# CITY OF ALBUQUERQUE

**Re: Starbucks**  
**2004 Wyoming Blvd. NE**  
**Traffic Circulation Layout**  
Engineer's Stamp 05-09-23 (H20-D003E)

Based upon the information provided in your submittal received 05-11-23, the above referenced plan cannot be approved for Building Permit until the following comments are addressed:

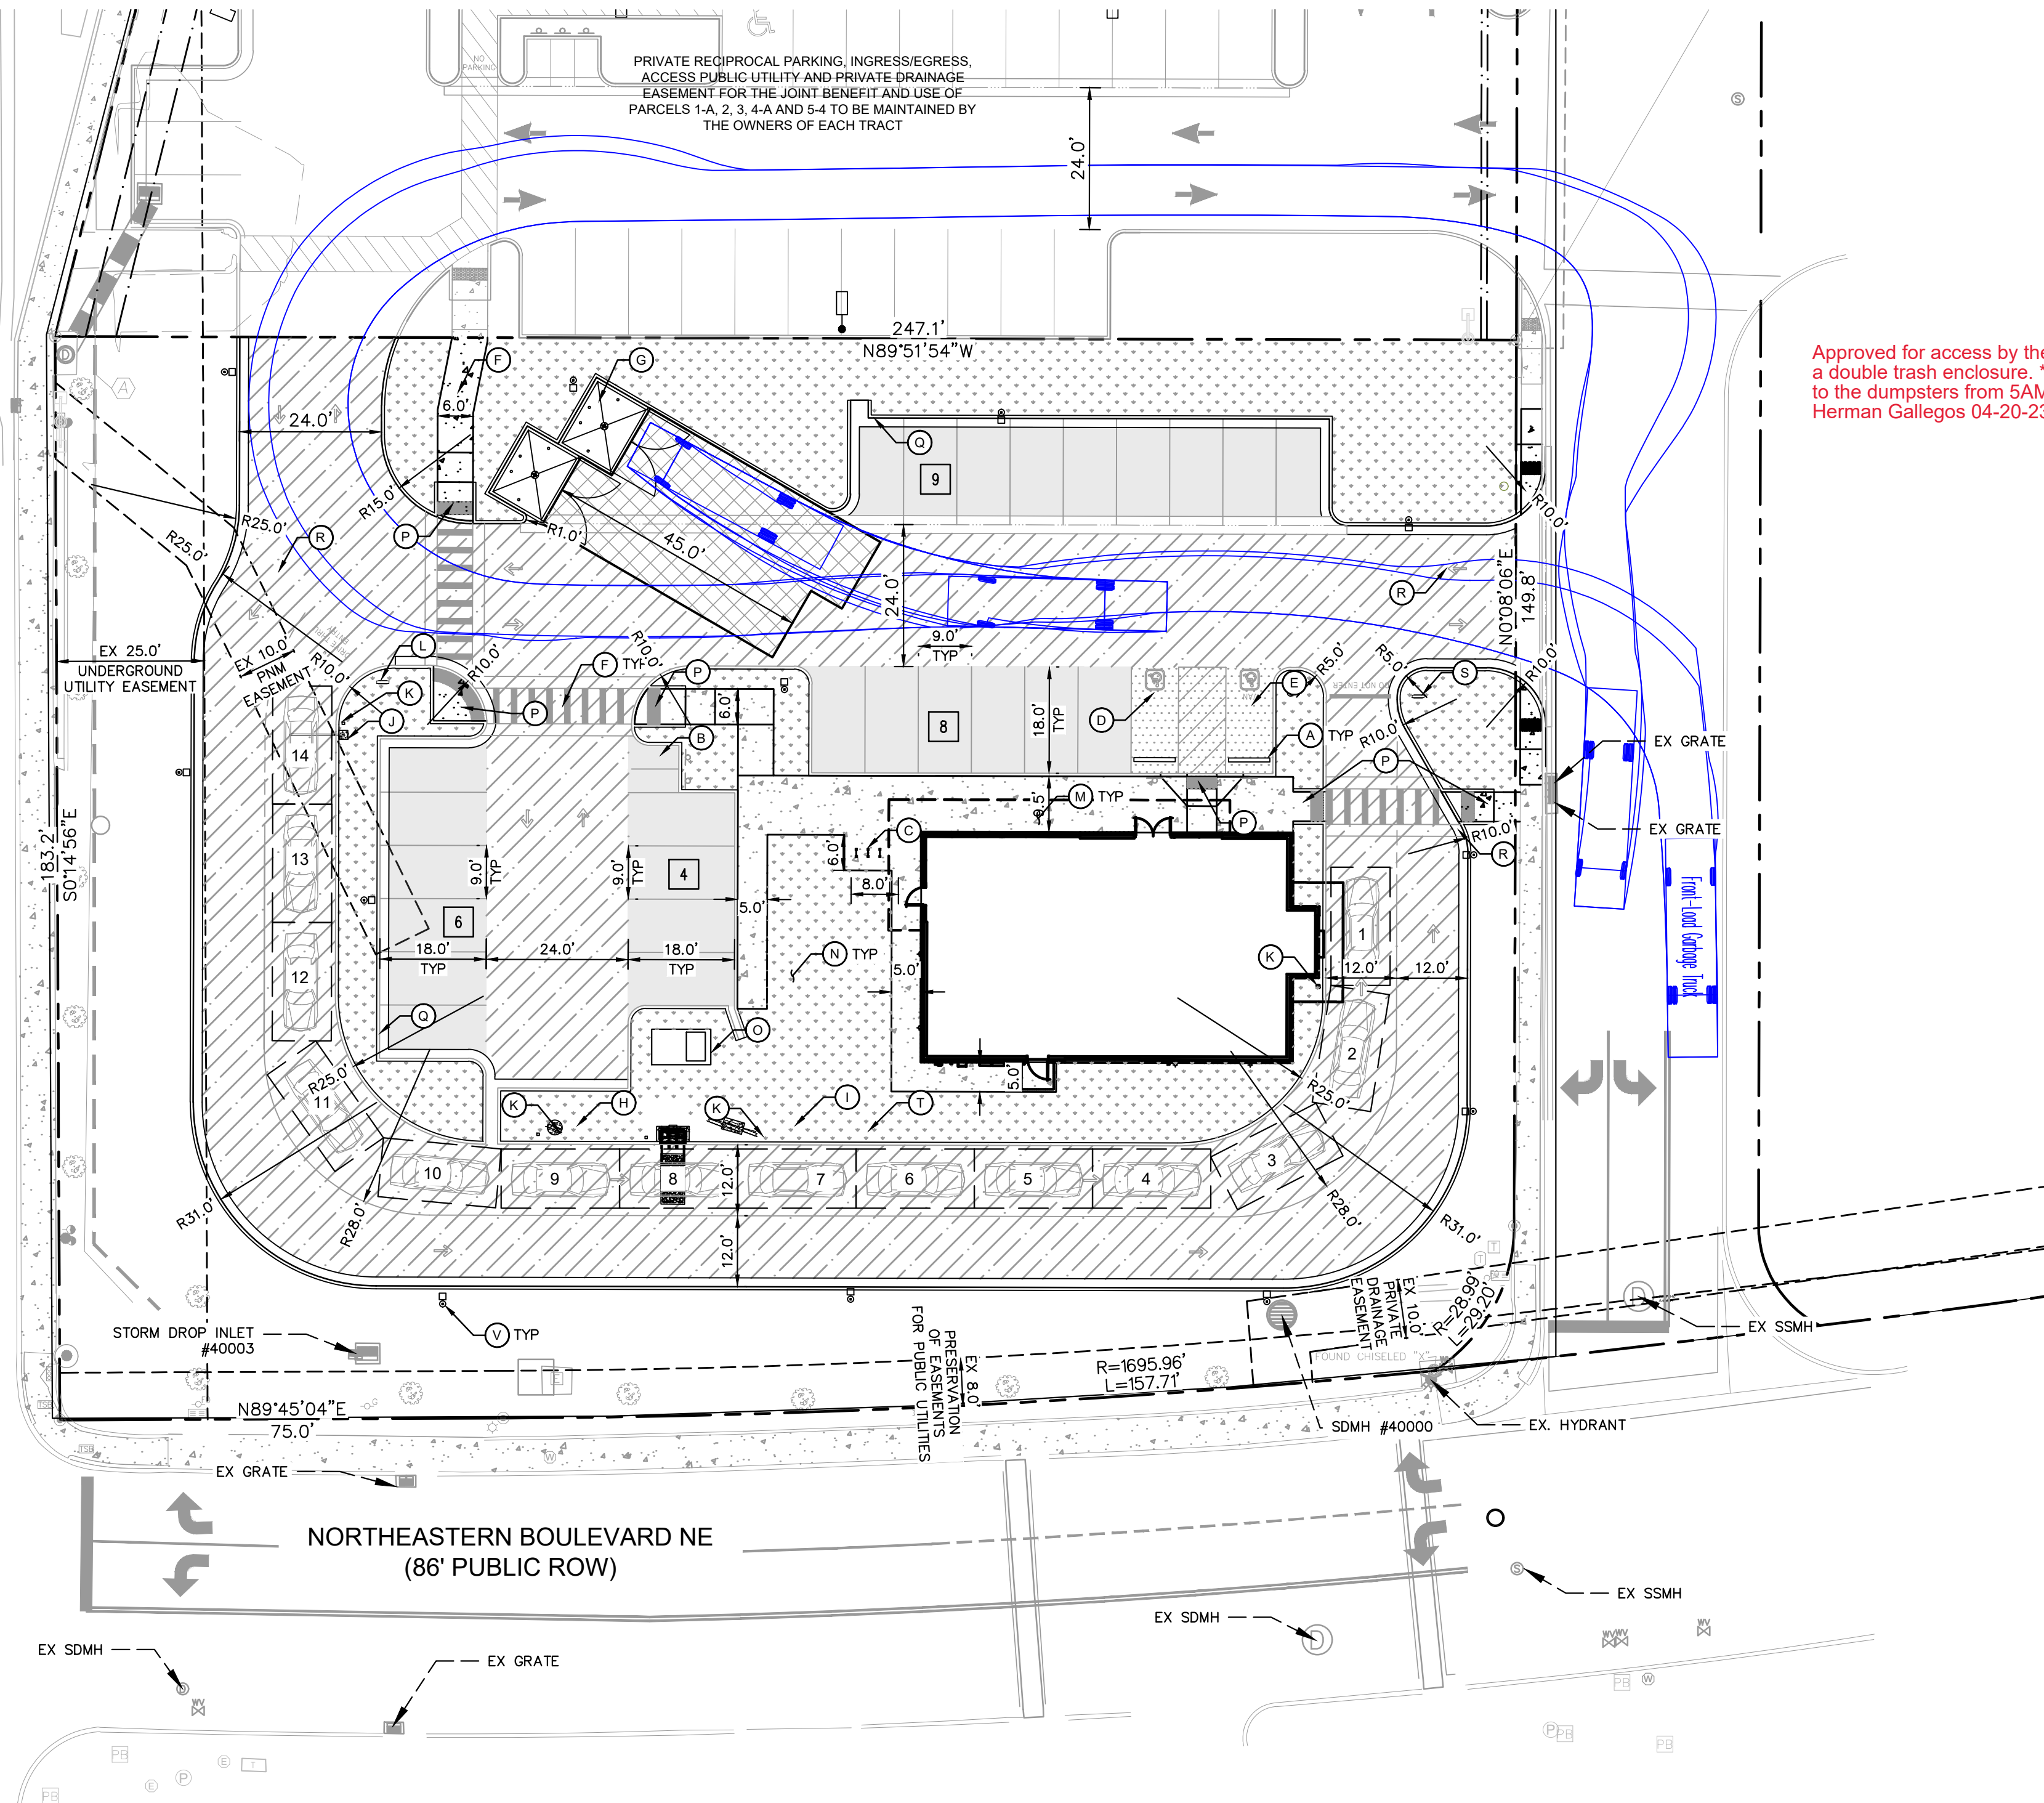
1. Identify all existing access easements and rights of way width dimensions.
2. PLEASE PROVIDE COPY OF Approved plat.
3. Show on the site plan site access radius.

4. ADA curb ramp at the corner of Wyoming Blvd. & Northeastern Blvd. must be updated to current standards and have truncated domes installed.
5. ADA curb ramp at the corner of Northeastern Blvd. and the Private Drive must be updated to current standards and have truncated domes installed.
6. The pavement marking "MC" should be shown in the opposite direction for motorcycles entering the parking space.
7. All bicycle racks shall be designed according to the following guidelines:
  - a. The rack shall be a minimum 30 inches tall and 18 inches wide.
  - b. The bicycle frame shall be supported horizontally at two or more places. Comb/toaster racks are not allowed.
  - c. The rack shall be designed to support the bicycle in an upright position. See the IDO for additional information.

- d. The rack allows varying bicycle frame sizes and styles to be attached.
- e. The user is not required to lift the bicycle onto the bicycle rack.
- f. Each bicycle parking space is accessible without moving another bicycle.
8. Bicycle racks shall be sturdy and anchored to a concrete pad.
9. A 1-foot clear zone around the bicycle parking stall shall be provided.
10. Bicycle parking spaces shall be at least 6 feet long and 2 feet wide.
11. Please show on the site plan the ADA Pedestrian pathway width.
12. Please show this dimension on the site plan.

13. The ADA access aisles shall have the words **"NO PARKING"** in capital letters, each of which shall be at least one foot high and at least two inches wide, placed at the rear of the parking space so as to be close to where an adjacent vehicle's rear tire would be placed. (66-1-4.1. B NMSA 1978).
14. ADA details on sheet C4.2 do not match ADA parking spaces on sheet C4.0.
